CITY OF ALBUQUERQUE

March 24, 2023

Re: Veterans Integration Center
2701 Mulberry St. SE
Traffic Circulation Layout
Architect's Stamp XX-XX-XX (M15-D054)

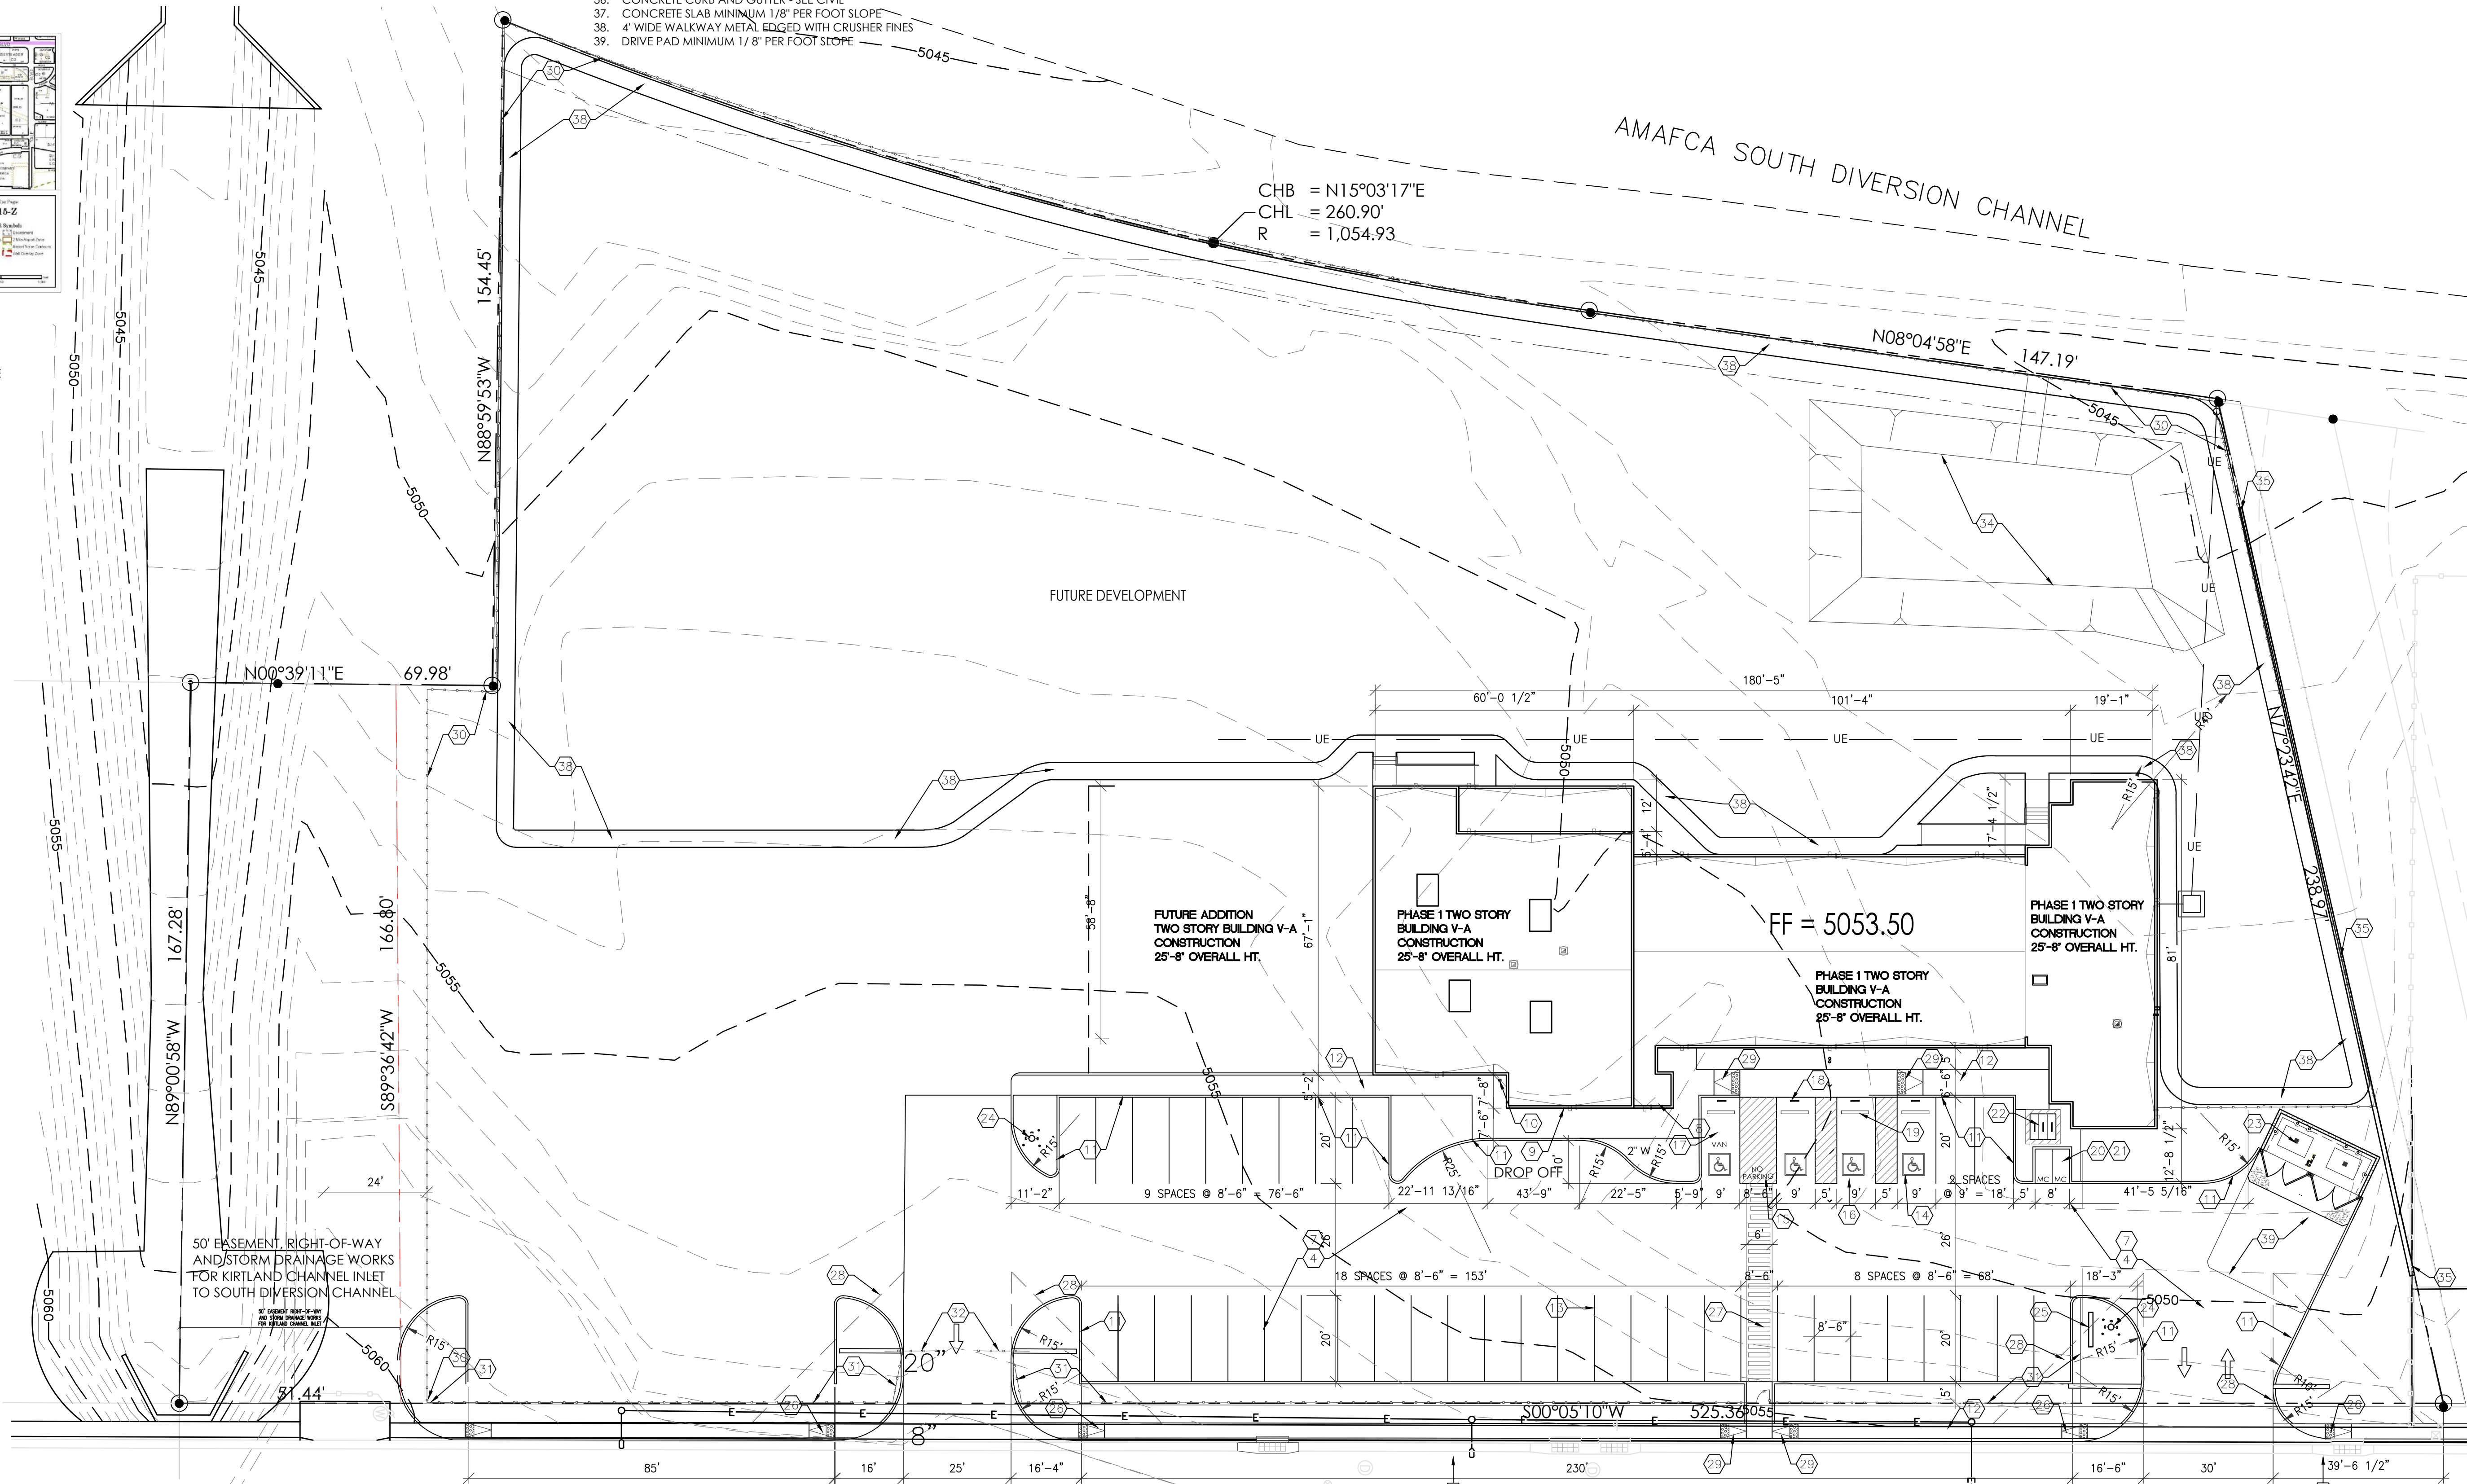
1. Identify the right of way width, medians, curb cuts, and street widths on Mulberry St.
2. Please define the property line.
3. Please provide a date on the Architect stamp.

4. Provide the existing sidewalk width.
5. Please show on the site plan the main building entrance.
6. Is there a third access at the south side of the site? If so, please provide details such as radii and access width.

7. Key note 28: detail A15 is missing.
8. Show the clear sight triangle and add the following note to the plan: "Landscaping and signage will not interfere with clear sight requirements. Therefore, signs, walls, trees, and shrubbery between 3 and 8 feet tall (as measured from the gutter pan) will not be acceptable in the clear sight triangle.

9. Please show on the site plan the word "NO PARKING" on each ADA aisle.
10. Provide a copy of Fire Marshal approval.
11. On the details sheet, please provide Transportation details only. We stamp and approve transportation details only.

12. Please specify the City Standard Drawing Number when applicable.
13. Add a note stating "All broken or cracked sidewalk must be replaced with sidewalk and curb & gutter." A build note must be provided referring to the appropriate City Standard drawing.
